**From:** [REDACTED]  
**To:** [Cleve Hill Solar Park](#)  
**Subject:** Cleve Hill Solar Park EN010085 Ref 20018862 - Objection ACL report - Oral presentation summary  
**Date:** 31 July 2019 22:10:28

**Cleve Hill Solar Park Development – Agricultural Land Classification – Objections – Summary of Oral Presentation on Tuesday, 16<sup>th</sup> July 2019**

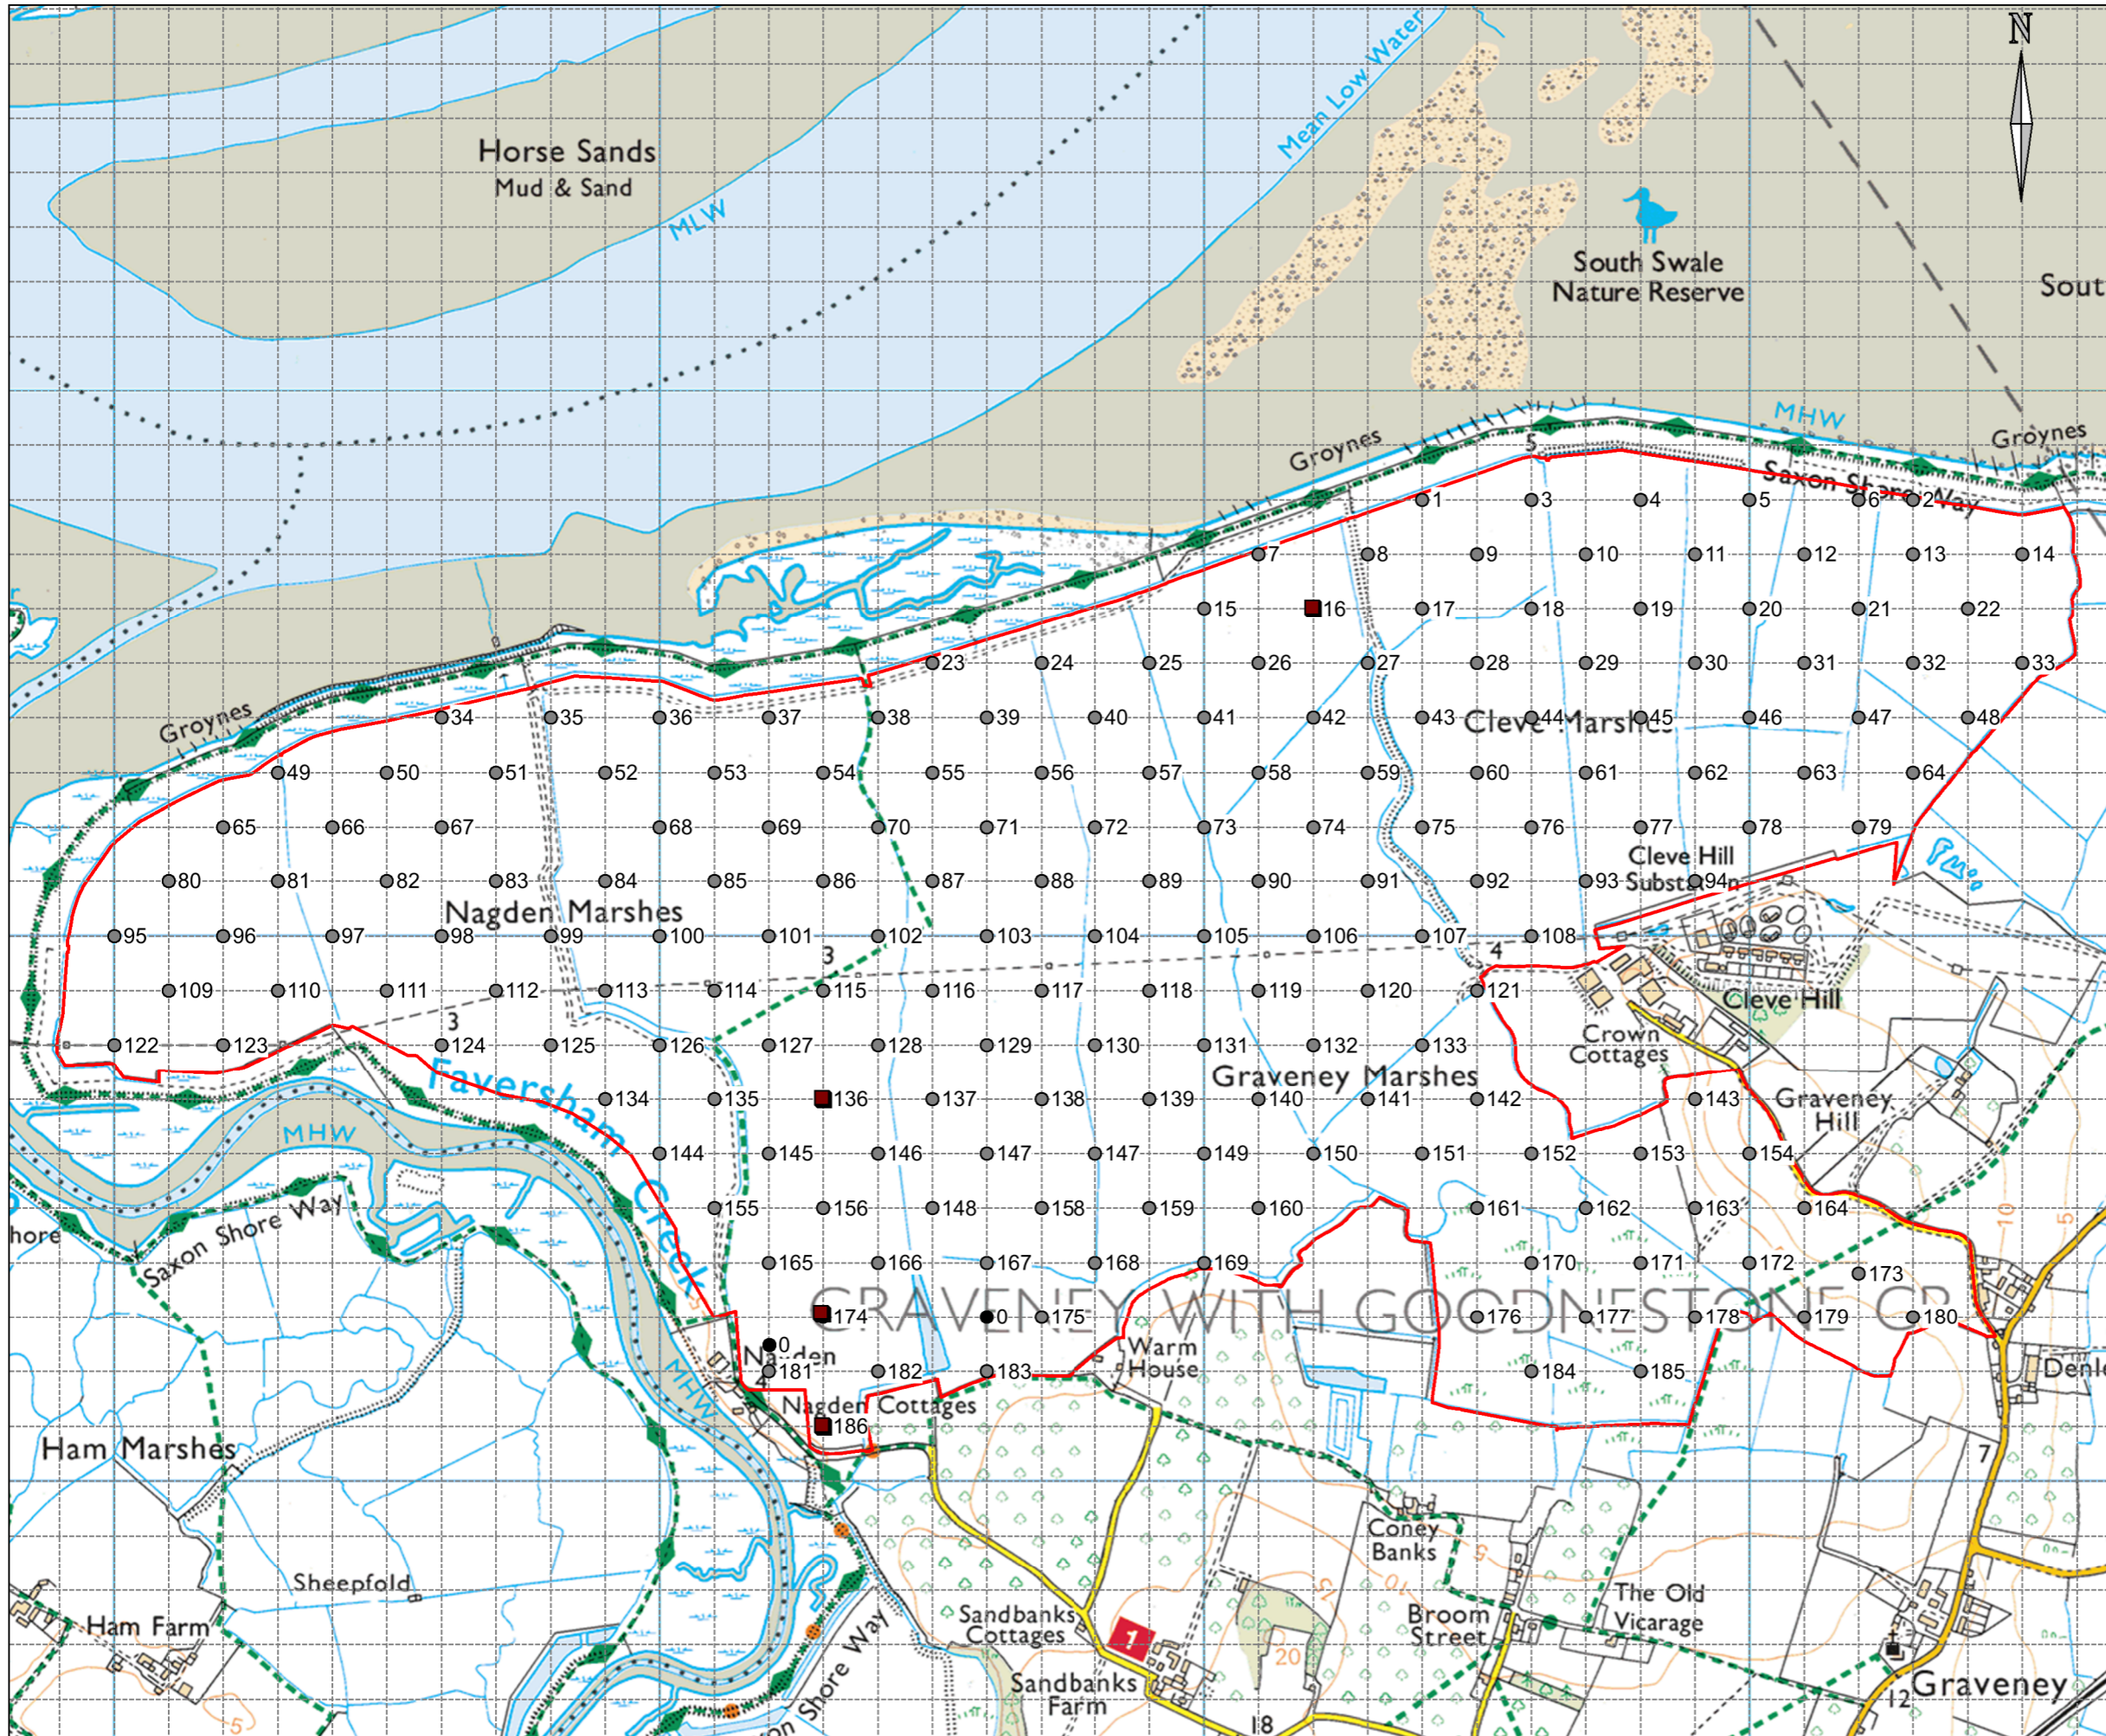
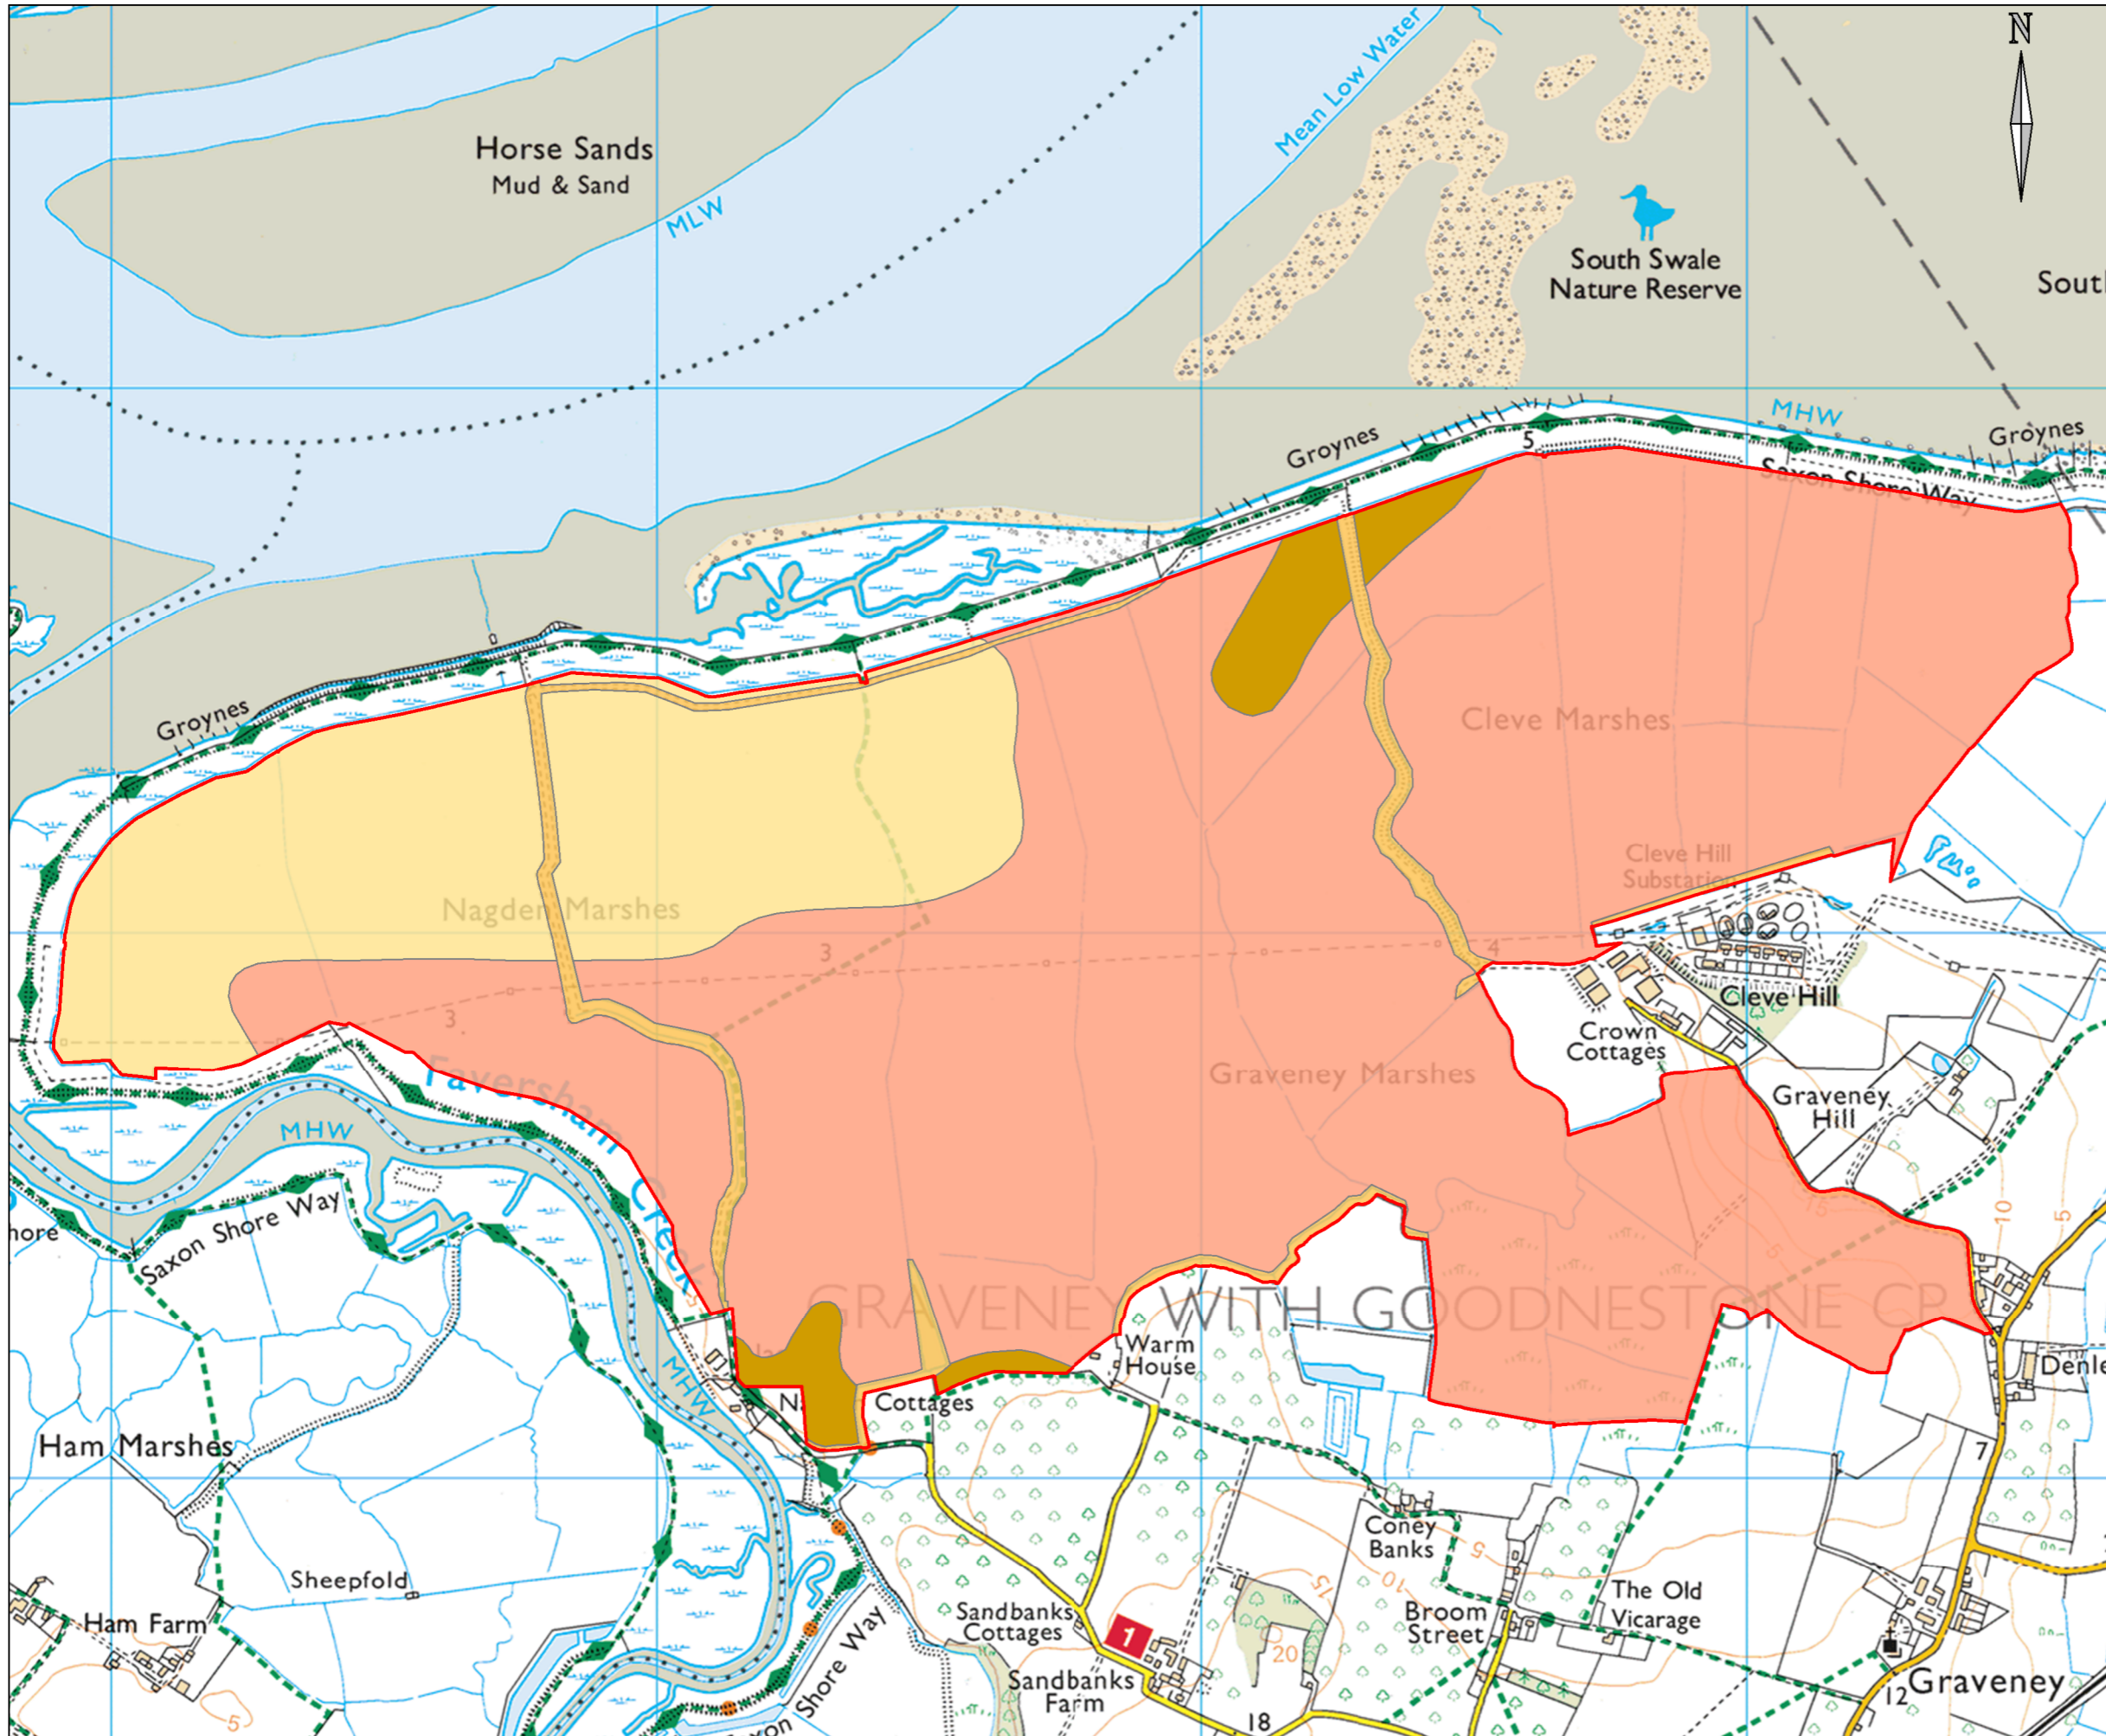
However, by a more detailed assessment of the field observation presented in the same report, I noted that the ALC report did in fact not follow the MAFF 1988 guidelines. I also stated that the field survey was 'biased' in relation to being undertaken at the time of year following an extremely wet February 2017 followed by two weeks of rainfall during the duration of the field survey at the beginning of March 2017.

I also mentioned that the report was incomplete and had missing data and that some assessment criteria to determine Wetness Class for two observation locations have been incorrectly interpreted.

I detailed that a large number of observation points have been entirely incorrectly interpreted in accordance with MAFF 1988 guidelines based on the presence of calcium carbonate in the soils. As each field survey sampling point was equivalent to about 2 ha of land, a considerable percentage of land could be reclassified as Grade 3a based on this fact alone.

I detailed that no quantitative data (as defined by the MAFF 1988 guidelines) has been presented in the report demonstrating that the soils at the site are water logged for the duration of more than 91-180 days.

I made reference to a local metrological monitoring station in close proximity to Cleve Hill Farm. I stated that I re-evaluated the Wetness Class across the site, based on actual and local metrological data and considering that a large part of the land has naturally calcareous soils, it was my opinion that over 75% of the land at Cleve Hill Farm can be graded as Grade 2 (very good agricultural land) and Subgrade 3a (good agricultural land) in accordance with MAFF 1988 guidelines.
